**From:** [REDACTED]  
**To:** [A303 Stonehenge](#)  
**Subject:** Written summary of submissions made by Consortium of Archaeologists and the Blick Mead Project at Issue Specific Meetings on 5 & 6 June 2019  
**Date:** 21 June 2019 22:43:00  
**Attachments:** [REDACTED]  
**Importance:** High

**Written Summary of submissions made at oral hearings on 5 and 6 June 2019 and the implications of this evidence for the HIA, the Heritage Assessment and the decision**

**WRITTEN SUMMARY ON BEHALF  
OF THE CONSORTIUM OF ARCHEOLOGISTS  
AND THE BLICK MEAD PROJECT TEAM**

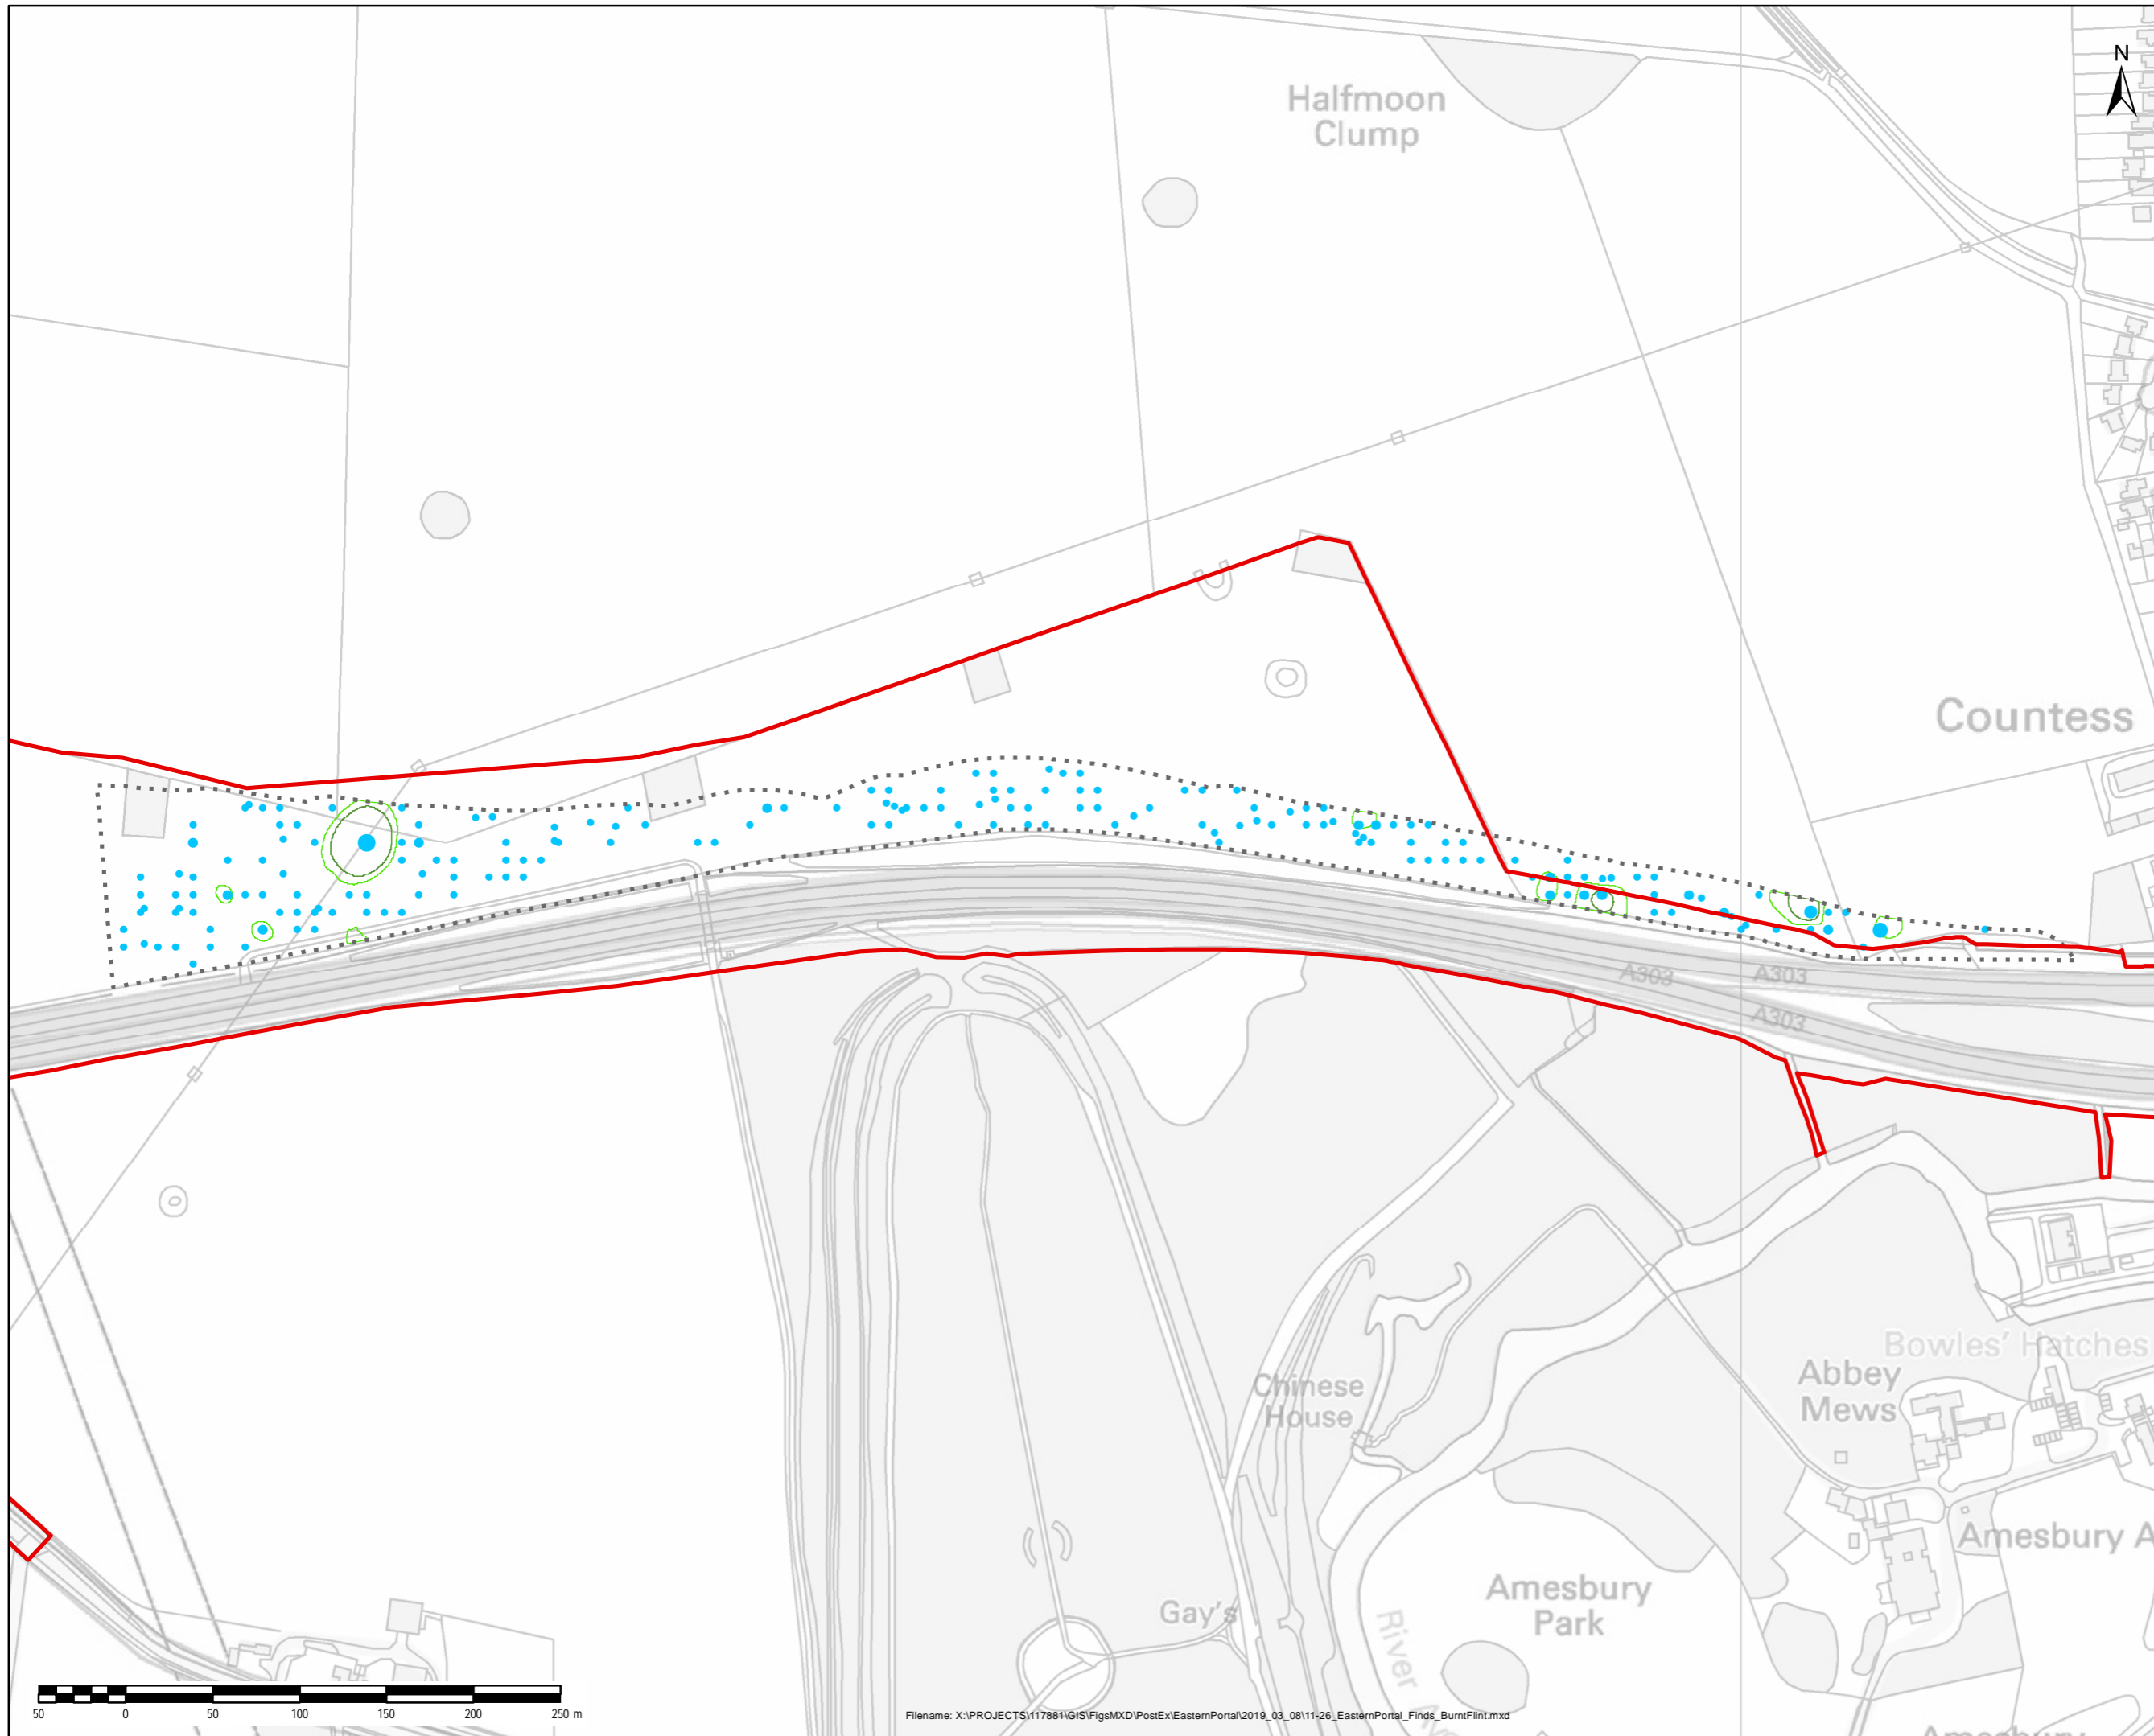
39. Eastern Approach – overall a lower density of artefacts. I haven't been able to find a plan on which the actual road alignment is marked.
40. On same principle of working out average numbers – we are looking around 3.6 worked flints per square metre. About half the density found on average in the western approach. First thoughts were that it is a bit low.

41. What we were then able to do is see some of the finds that Wessex Archaeology have made. Interestingly here in this part of the landscape small numbers of likely Early Neolithic blades were found. . What is important about this area is it offers the chance to ask a question about the relationship of that early Neolithic activity between east and west. There is a general question. Is it a series of small focussed clusters or a general spread across the area? You can only answer that question if you increase the sampling intensity to 100%.
